From: Contact Centre (CRM) <contact@ribblevalley.gov.uk>
Sent: 06 March 2025 10:15
To: Planning
Subject: Planning Application Comments - 3/2025/0100 FS-Case-693466866

Planning Application Reference No.: 3/2025/0100

Address of Development: Land at The Eagle at Barrow Clitheroe Road Whalley BB7 9AQ

proposed site plan
scale - 1:250@ A1 / 1:500 @ A3

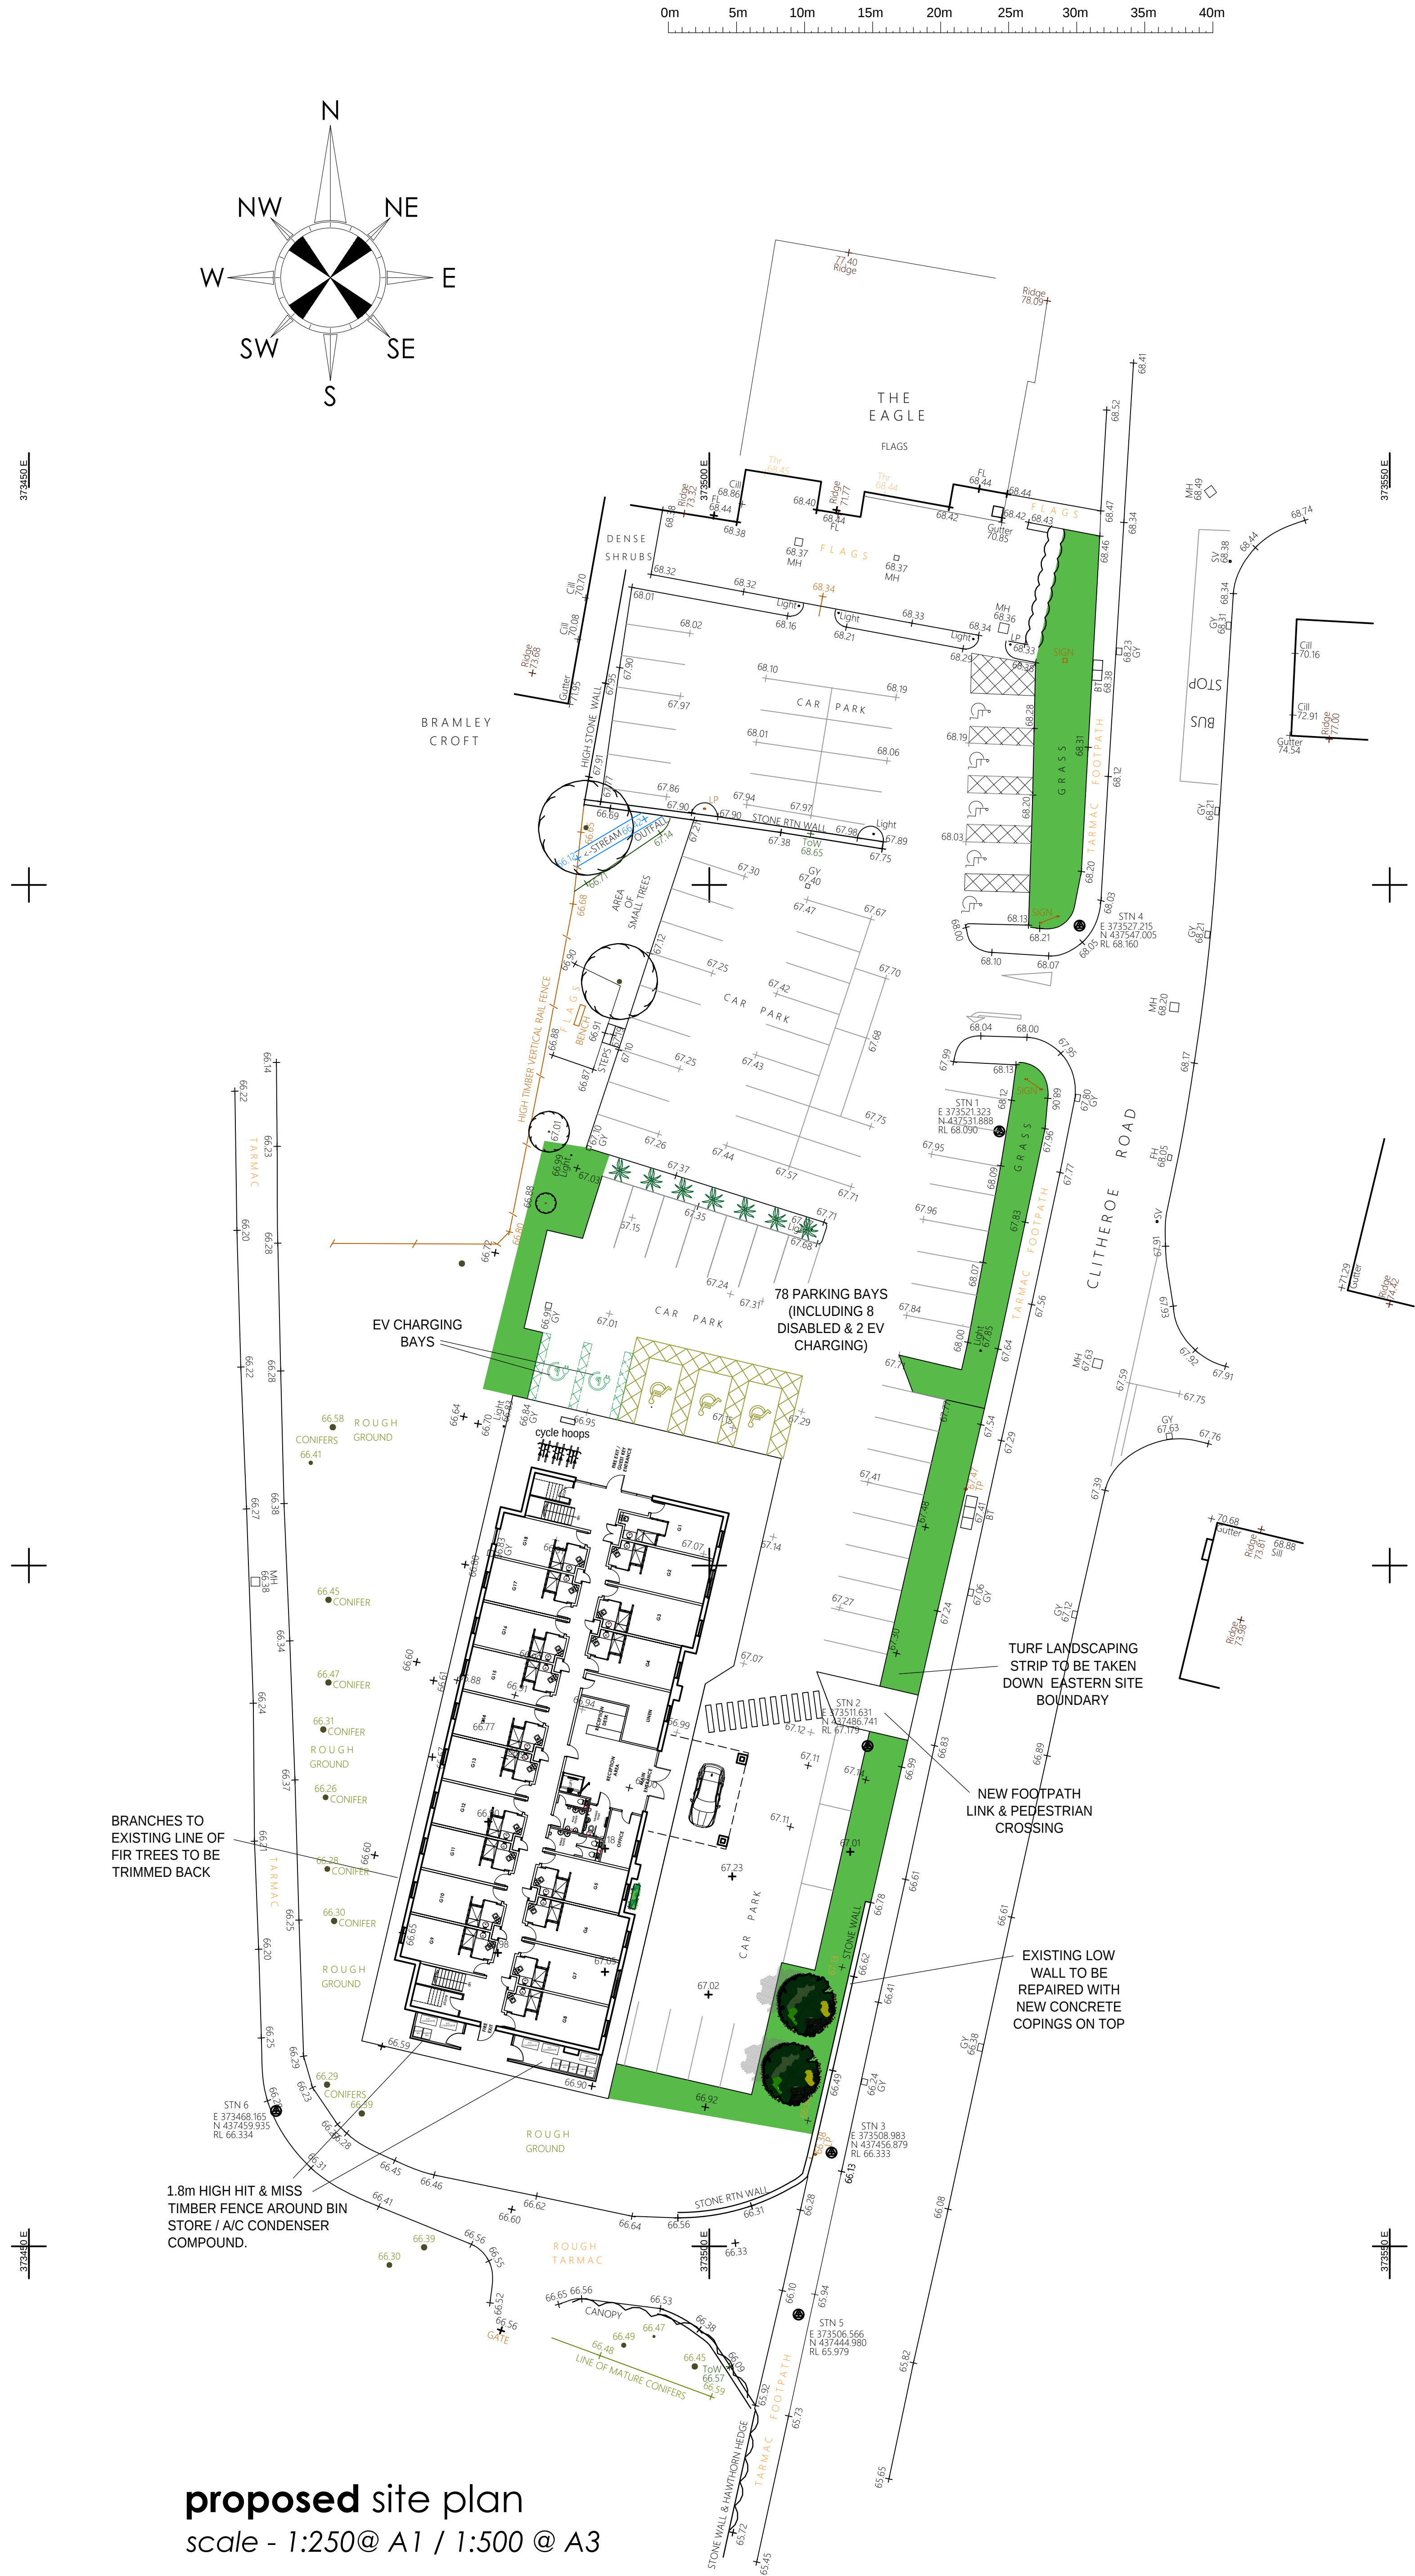
The large car park will have high traffic in and out. [REDACTED] I would like to see some protected pathways that segregate people from the car traffic. As the route from the hotel and restaurant will have a high footfall

Secondly, this venue is set up for families to attend for meal, sleeping and weddings etc. there does not appear to be anywhere safe for children to play outside, ie a park or green area. This will result in children playing in the car park, which further highlights concerns raised in point 1. Could a segregated play area be provided to safeguard the children?
